Sheringham Shoal and Dudgeon Offshore Wind Farm Extension Projects

Addendum to the Flood Risk Assessment

Revision A

March 2023

Figure 9-23: 1 in 100 year plus 45% for climate change with OnSS platform level set at 28.23m AOD and NW access road

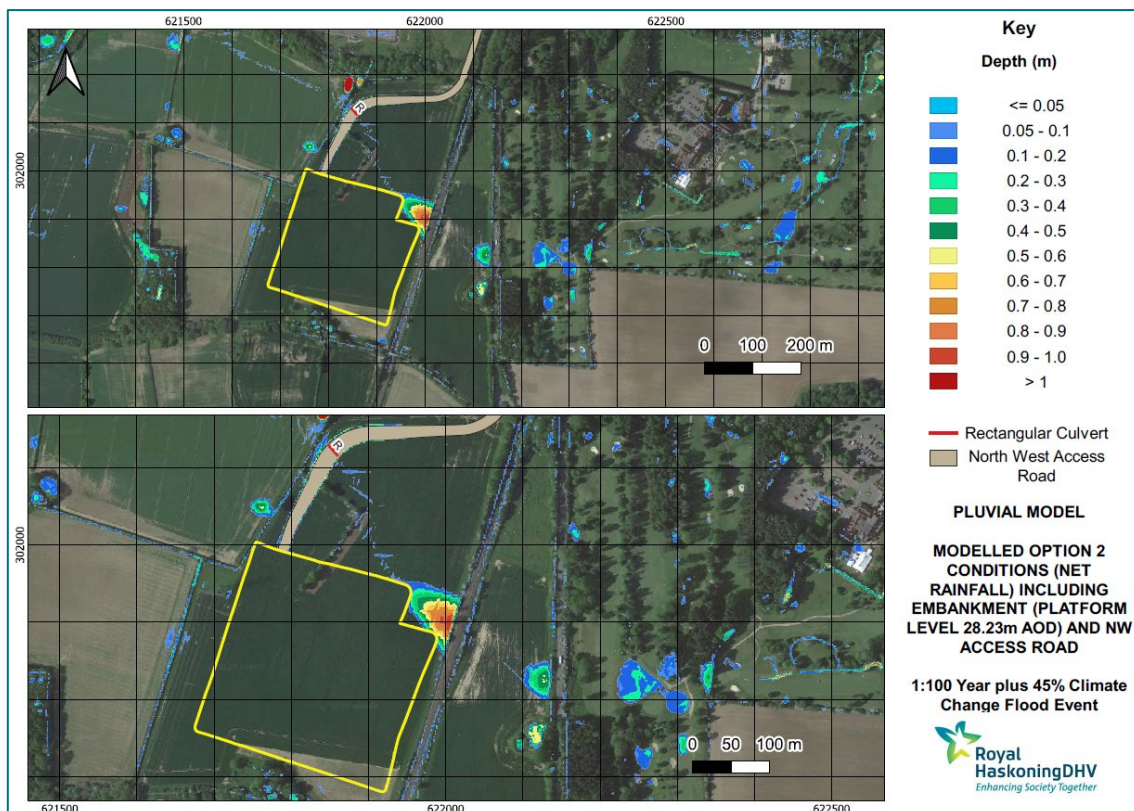
3. An updated hydraulic model that appropriately applies the latest climate change allowances and provides an assessment of the change in flood risk.

28. With regards to the consideration of climate change allowances, following discussions with the LLFA at a meeting on 6th December 2022, minor updates to the surface water hydraulic modelling have been undertaken.
